Urban Design Review Panel Report 1822 Bank Street

RE: Urban Design Review Panel Report

Official Plan Amendment, Zoning By-law Amendment, and Plan of Subdivision Applications 1822 Bank Street

DRAWING TITLE:
 BUILDINGS 2
 ELEVATIONS

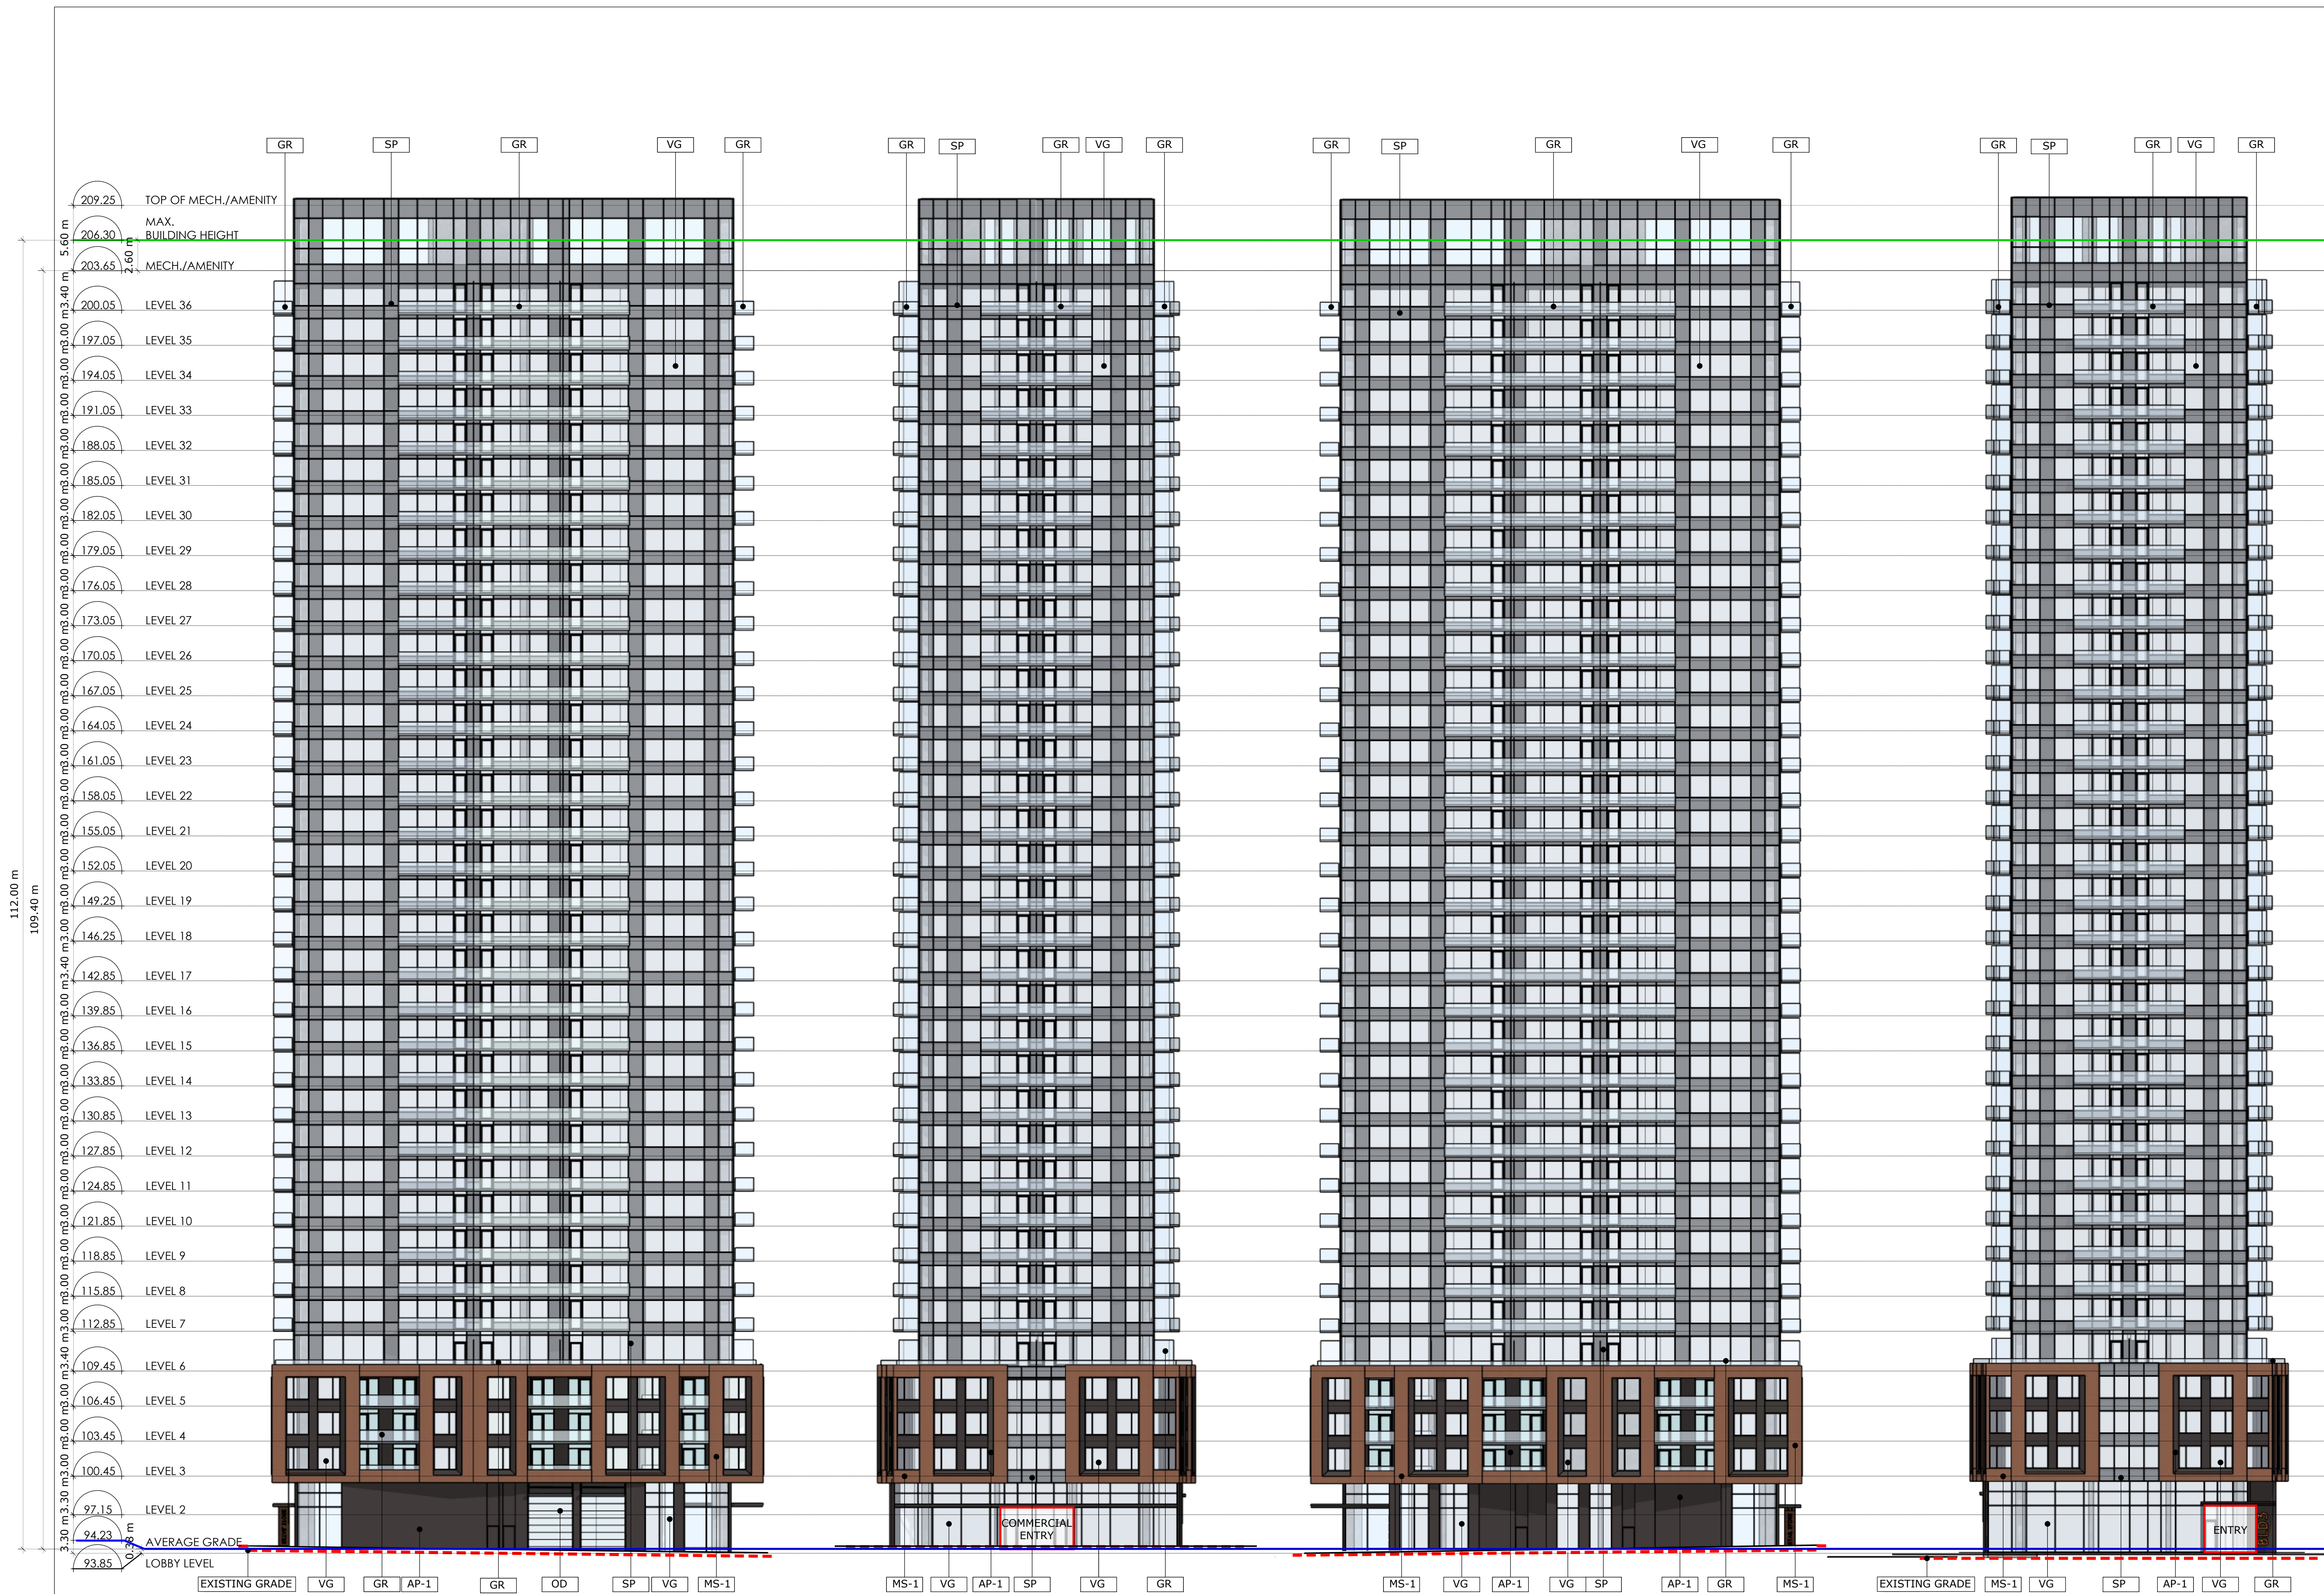
27. The Panel has some concerns with the 6-storey podium heights as it diminishes the relationship with the public realm. The Panel suggests a lower podium height, such as 4-storeys, would be more beneficial to the public realm and more comfortable for pedestrians, particularly when setting a standard for this section of Bank Street.

28. The Panel suggests Building 2 on the eastern edge of the site should go taller, bumping right up to meet the 45-degree angular plane shown on p.34 of presentation and perhaps even beyond it.

Response: The podium heights have been reduced to 4 stories for Buildings 1, 3, and 4. For Building 2 (corner of Bank and Walkley), the podium is proposed to be 5 storeys to provide a stronger anchoring form at the key intersection.

Response: Building 3 (formerly Building 2) has been increased in height to 33 storeys. This change offsets the reduction in height on Building 1 (formerly building 5) at the southwest corner.
